Lr.No.A1/30043/2000

Dated : 19-9-2000

Sub: CMDA - Planning Permission - Construction
of Residential/~~Commercial~~ Building at
Plot No.74, Manikudi Srinivasa Nagar
in S.No.18,19,29,30, 31 and 14/2B of
Seevaram Village -

SITE PLAN
 (SCALE: 1:16:10)

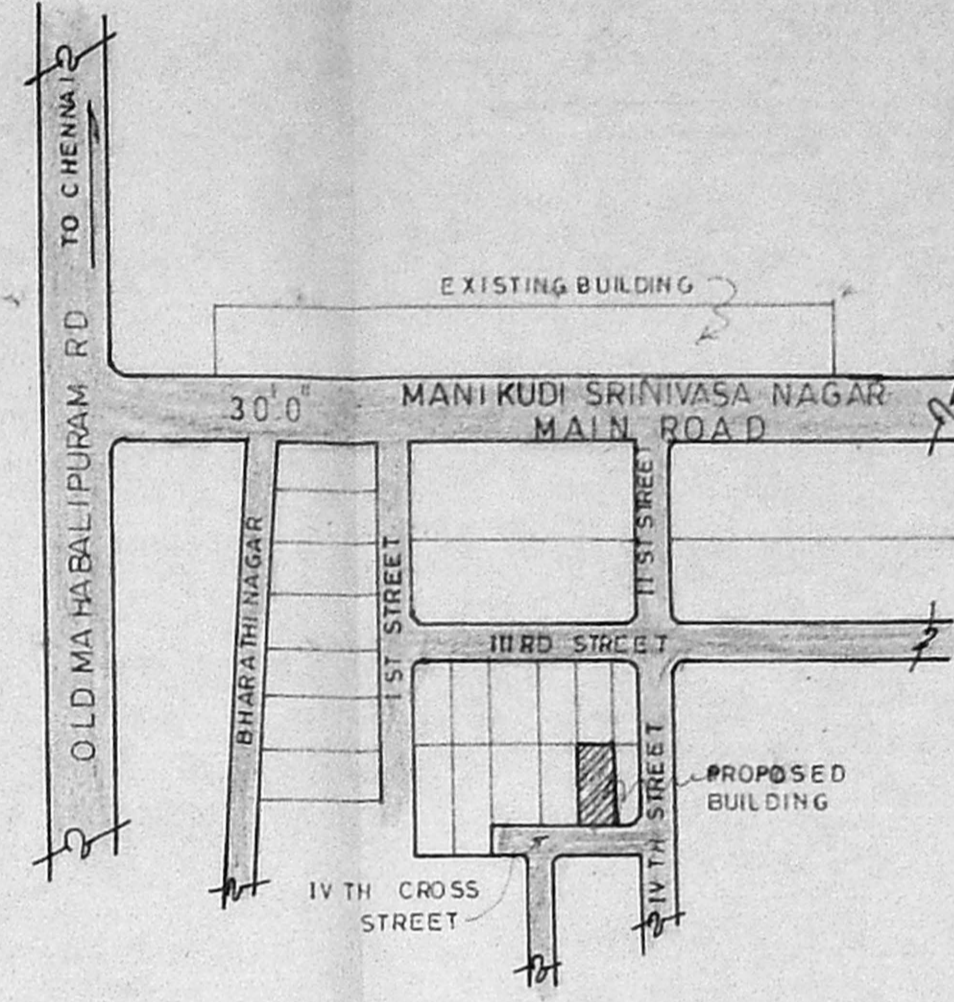
5) (*) Five copies of Revised plan showing the correct metric conversion, gates with dimension and Rain water harvesting fit.
